Matthew Rosel - Submission Details for

Submission for Job: #6010 SSD 6010 - One Residential Building (Student Accommodation) within Darling Drive Plot

SSD 6010 – One Residential Building (Student Accommodation) within Darling Drive

SHADOW DIAGRAMS: PERSPECTIVE, SHOWING THE PEAK, WINTER SOLSTICE

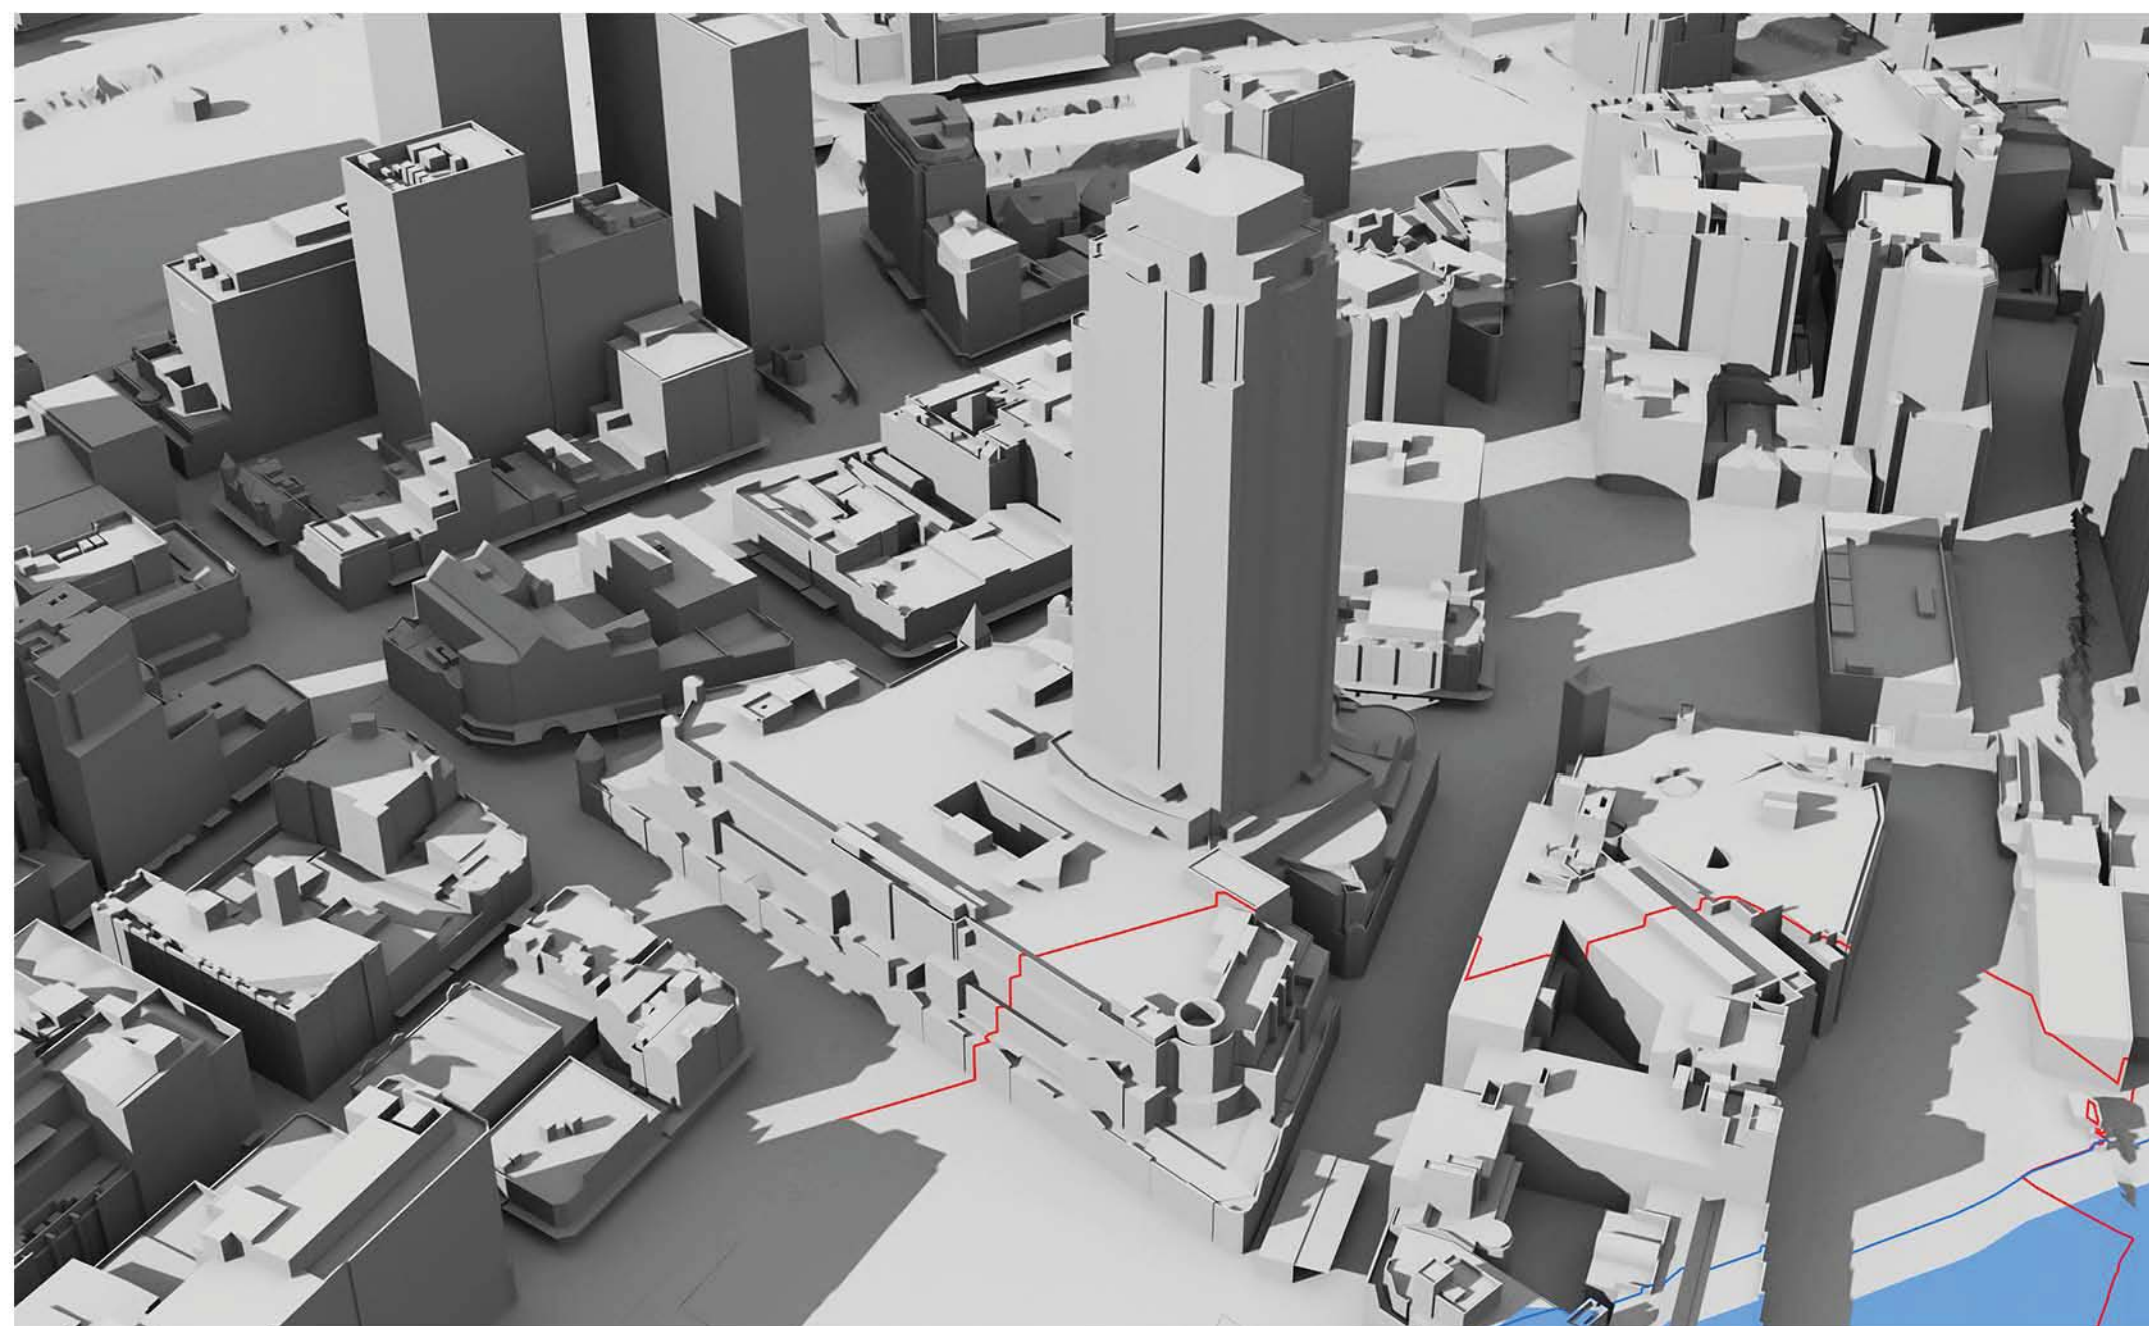
At 9am, 10am and 11am the west façade is totally in shadow due to other parts of The Peak building itself.

At 12pm there is still substantial existing shadowing on the west façade caused by the irregular shape of the west facade.

At 1pm the existing shadowing has been substantially removed, but not totally removed.

It can be concluded that some single aspect apartments on the west façade and some south-west dual aspect corner apartments currently receive less than 2 hours direct sunlight to habitable rooms and 50% of the private open space between 9am and 3pm on 21 June.

By 2pm the existing shadowing has been totally removed, but that is too late to achieve two hours of direct sunlight before 3pm.

At 9am, 10am and 11am the west façade is totally in shadow due to other parts of The Peak building itself.

At 12pm there is still substantial existing shadowing on the west façade caused by the irregular shape of the west facade.

At 1pm the existing shadowing has been substantially, although not entirely, removed. However, overshadowing of lower levels of the west façade by the concept proposal parameter plan shadows for the N,NE and SE plots has already started.

By 2pm the existing shadowing has been totally removed. However, overshadowing of the west façade by the SSDA4 and SSDA5 buildings has appeared and risen further up the west façade than the concept proposal parameter plan shadows for the N,NE and SE plots, which is still present.

At 3pm, the proponent states correctly that 45-45% of the western façade is overshadowed by the SSDA4 and SSDA5 buildings.

It can be concluded that, as a result of combination of the proposed development with existing shadowing of the west façade, some single aspect apartments on the west façade and the south-west dual aspect corner apartments which currently receive less than 2 hours direct sunlight to habitable rooms and 50% of the private open space between 9am and 3pm on 21 June will suffer additional overshadowing. It is beyond our skills to count the number of such apartments. We note that the proponent has made no attempt to do so.

Rather than counting the number of units which will not meet the DCP guidelines, the proponent attempts to trade-off direct sunlight at 4pm for lack of direct sunlight during the period 9am to 3pm. There is no provision in the DCP guidelines for such a trade-off.
